PLEASANT MEMORY BAPTIST CHURCH

Subject: Pleasant Memory Baptist Church

This letter is in regard to your Permit Review dated 11/8/2022. Our Deacons have contacted Mr. Brad Sutton and Mr. Roger Sullivan concerning their requested information.

PLEASANT MEMORY BAPTIST CHURCH

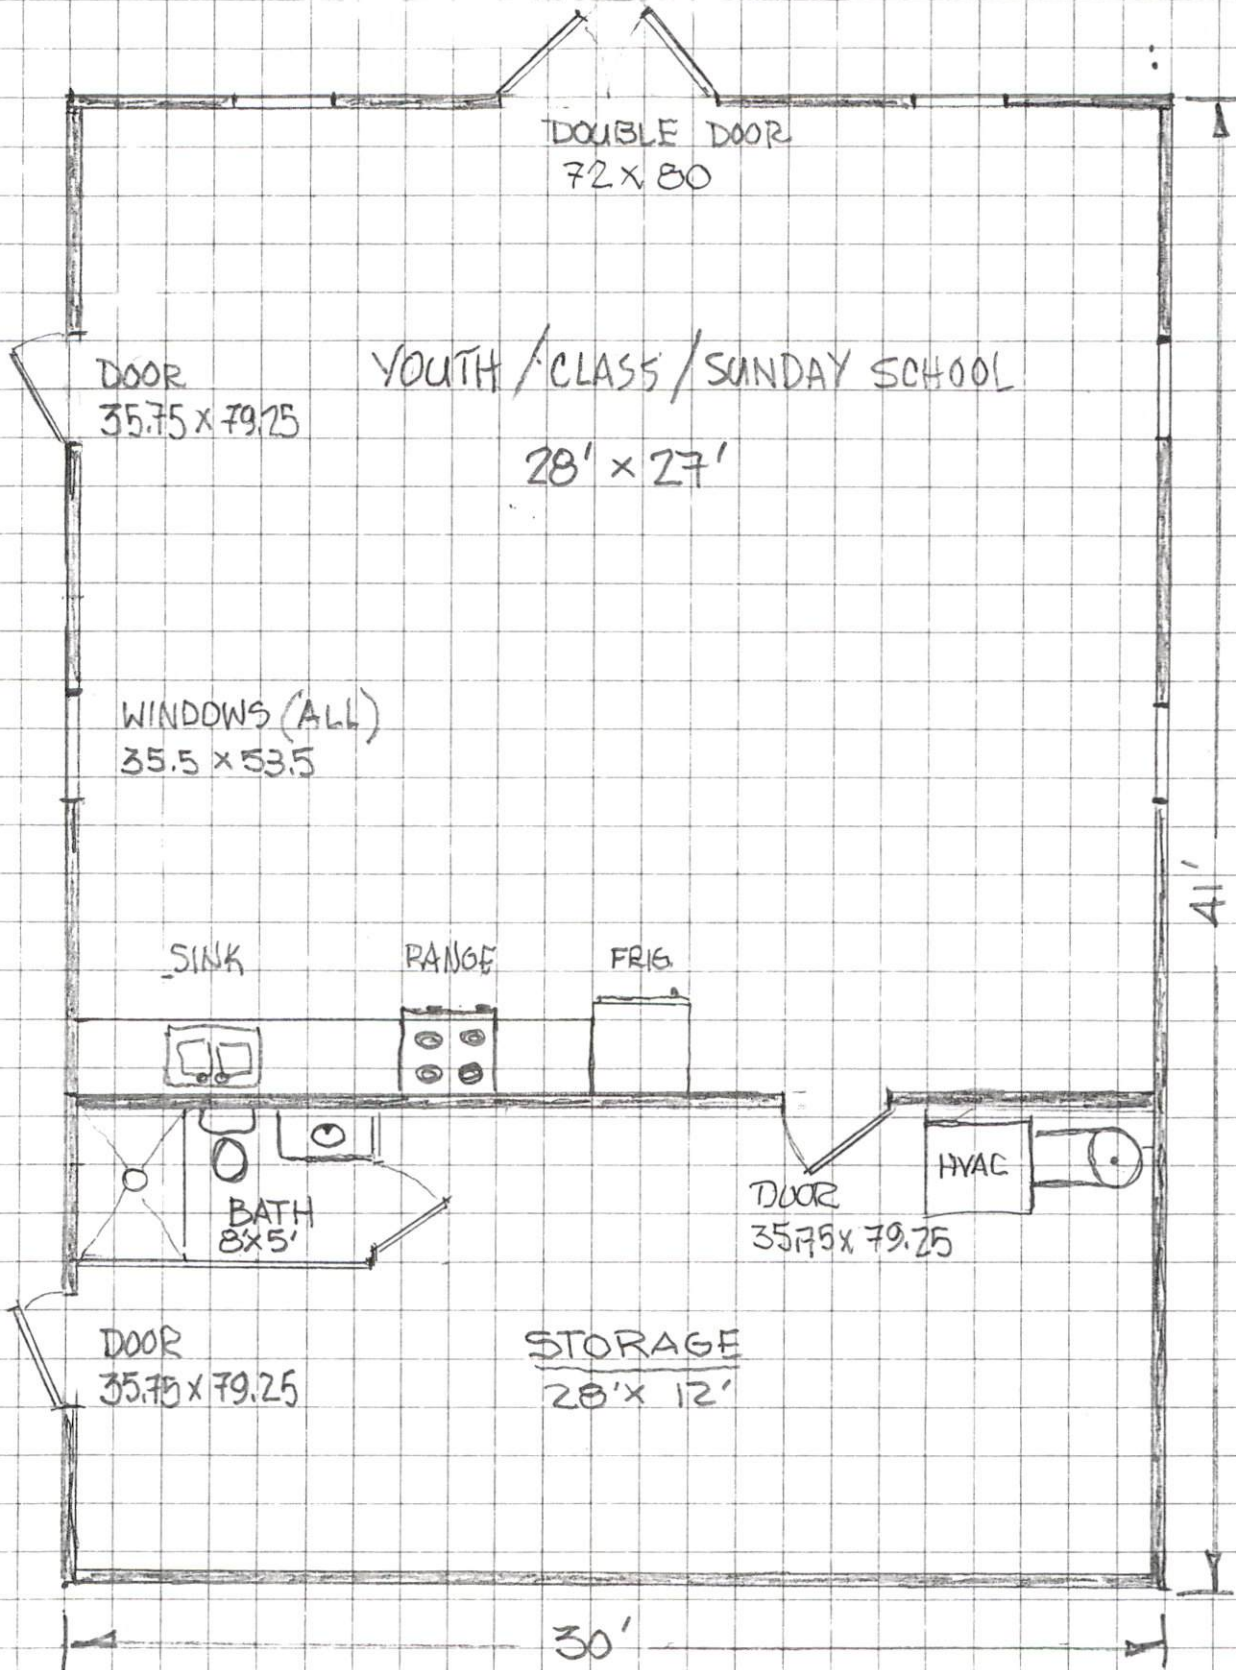
Mr. Sullivan required there be a fire hydrant within 400 feet and we showed him there were two fire hydrants that met this requirement. He also required Emergency exit lights be mounted over exit doors and fire extinguishers be mounted on the wall beside these doors. These lights and extinguishers are shown on the attached drawing. The kitchen facilities and bathroom are to be added later.
